### **Saddlehorn (824 Acres), SF-19-12**

**Please accept the following comments from El Paso County Public Health regarding the project referenced above:**

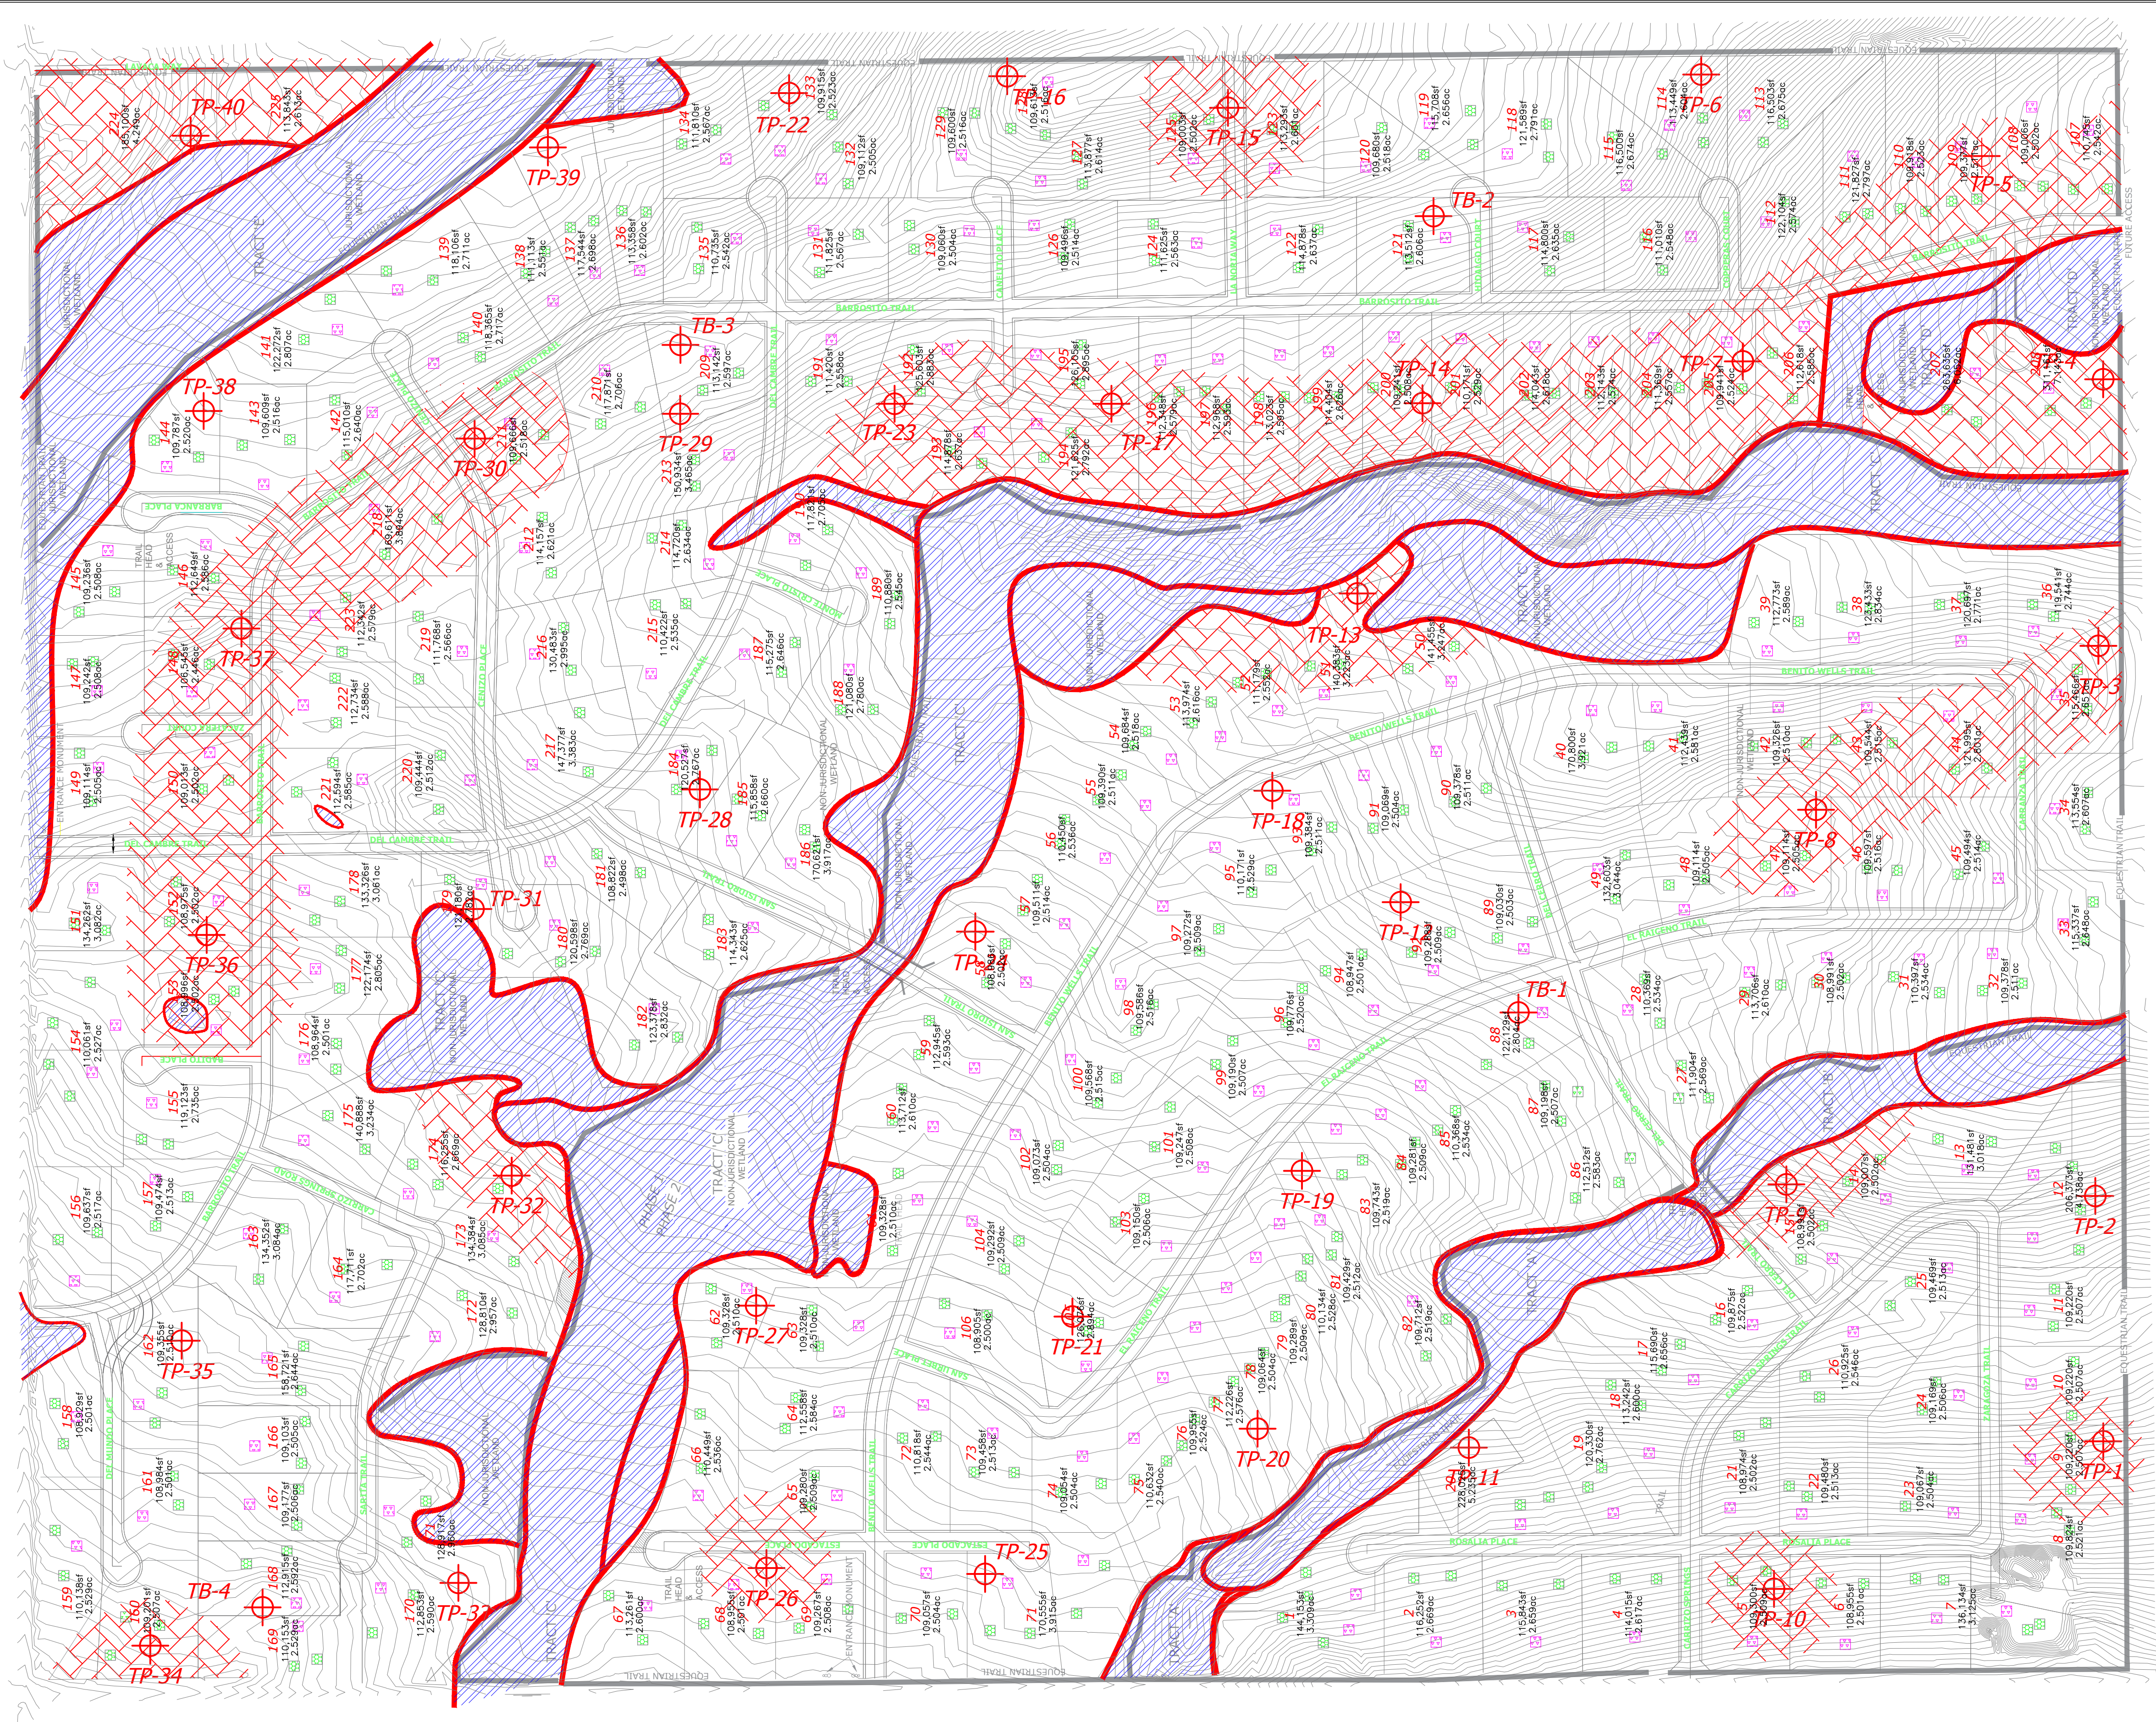
- **The use of onsite wastewater treatment systems (OWTS) is planned for the entire development. The Entech Engineering Soils, Geology, Geologic Hazards and Wastewater Study dated 29Apr2019, supports the use of OWTS in this area. The Entech Onsite Wastewater Treatment System Report Addendum dated 16July2019, is also consist with the original report findings. The required number of soil tests (45) were completed. Roughly half of the soil tests completed would require a Professional Engineer to design the OWTS due to shallow bedrock, clay soil layers with limiting absorption capabilities and in some cases shallow bedrock. All these limiting conditions are routinely encountered in El Paso County and can be safely addressed with proper system designs. In addition, there may be a more suitable location for an OWTS elsewhere on each lot.**
